**KIRKLEES METROPOLITAN COUNCIL
INVESTMENT & REGENERATION SERVICE**

Reference No: 2021/62/92068/W

Site Address: 7, Fenay Crescent, Almondbury, Huddersfield, HD5 8XY

Description: Erection of two storey side and rear extensions and single storey front extensions (modified proposal)

Project:	Job No:
FENAY CRESCENT	2020-012
ALMONDBURY	
Title:	
PROPOSED ELEVATIONS	
Scale:	Drawn by:
1:50@A1	
Date:	Checked by:
05.05.21	-
Drawing No:	Revision No:
(20)004	-

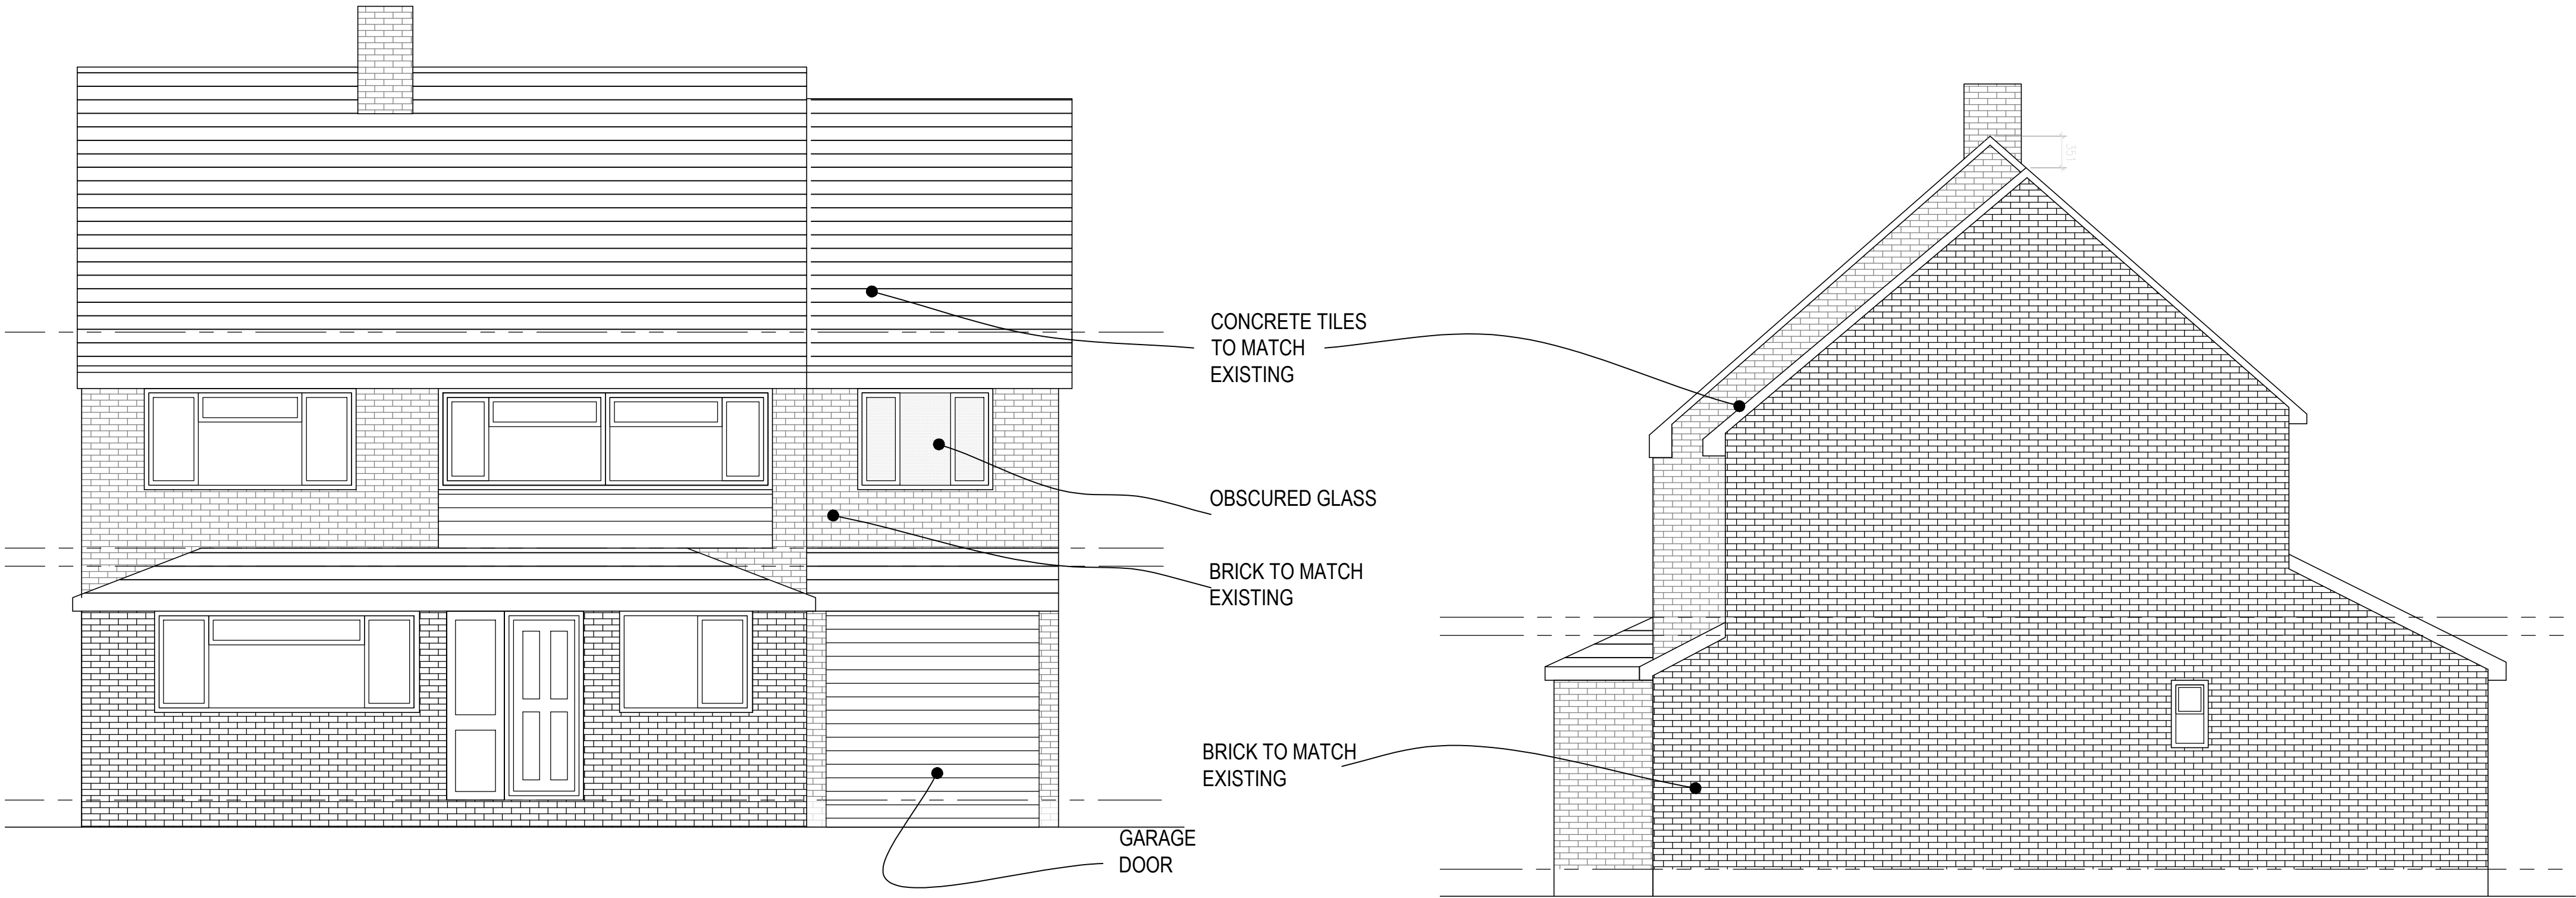
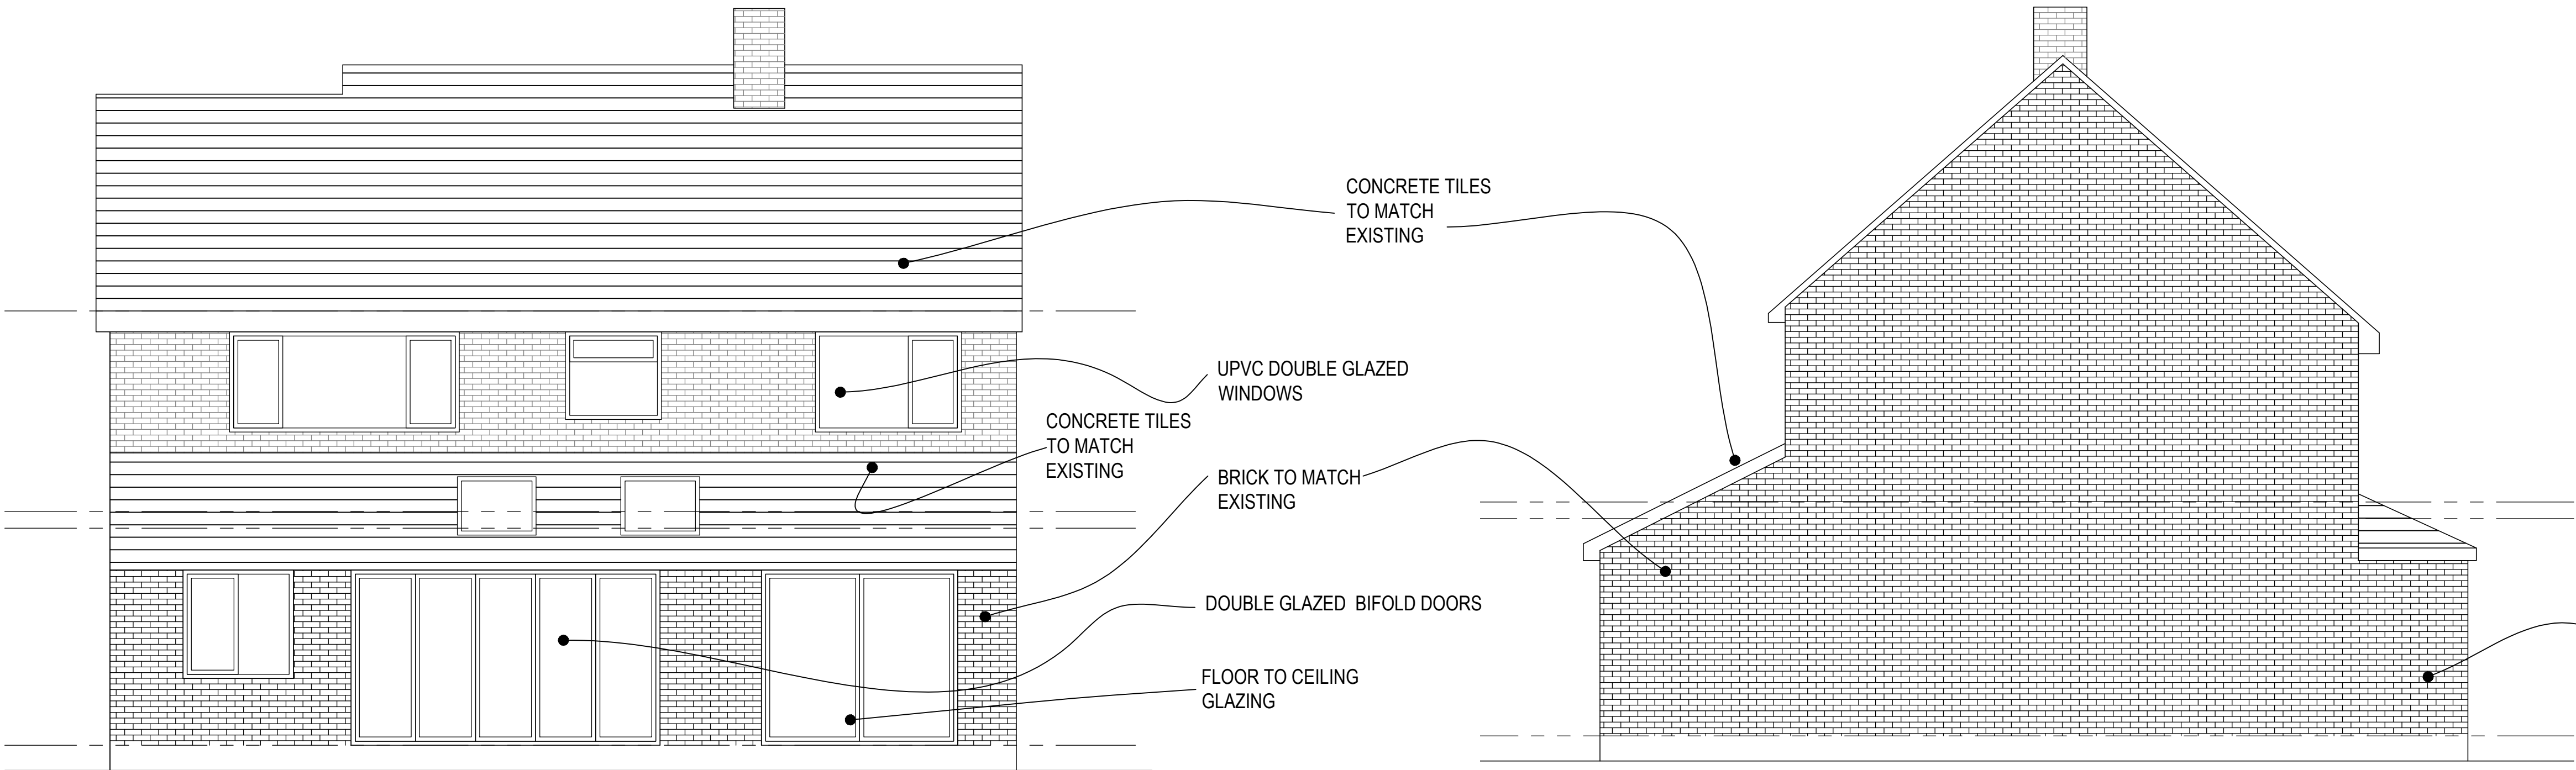
The side extension would project from the gable by 2.8m and the ground floor would be flush with the host property whereas approved it was set back from the front elevation by 0.8m and the first floor is set back 0.8m however as approved was set back 2m from the front elevation.

The side extension would have a dual pitched roof with the ridge set down, by approx. 0.4m, rather than the previous 1m.

The original plans showed the side extension flush with the front elevation, the agent was advised to set it back in line with the previous approved scheme, however the extension has been set back slightly but not as approved.

The side extension would be built close up to the boundary with No. 9 however the neighbour has an existing gap to the boundary of approx. 1.4m which is unlikely to be built on. In general, a larger gap is preferred in the case of two-storey side extensions, however in this case the ground floor is now flush but is single storey and first floor is set back 0.8m from the front elevation of the host property, albeit slightly forward now of the adjacent neighbour due to the staggered relation between properties, however, would still avoid the creation of a terracing effect, in this case as amended.

With regards to the side extension, which now projects forward to that already approved, where there still is a set back of 0.8m and given the staggered relationship between the neighbours to this side, the additional projection of the side extension is considered to have a marginal effect on No 9.
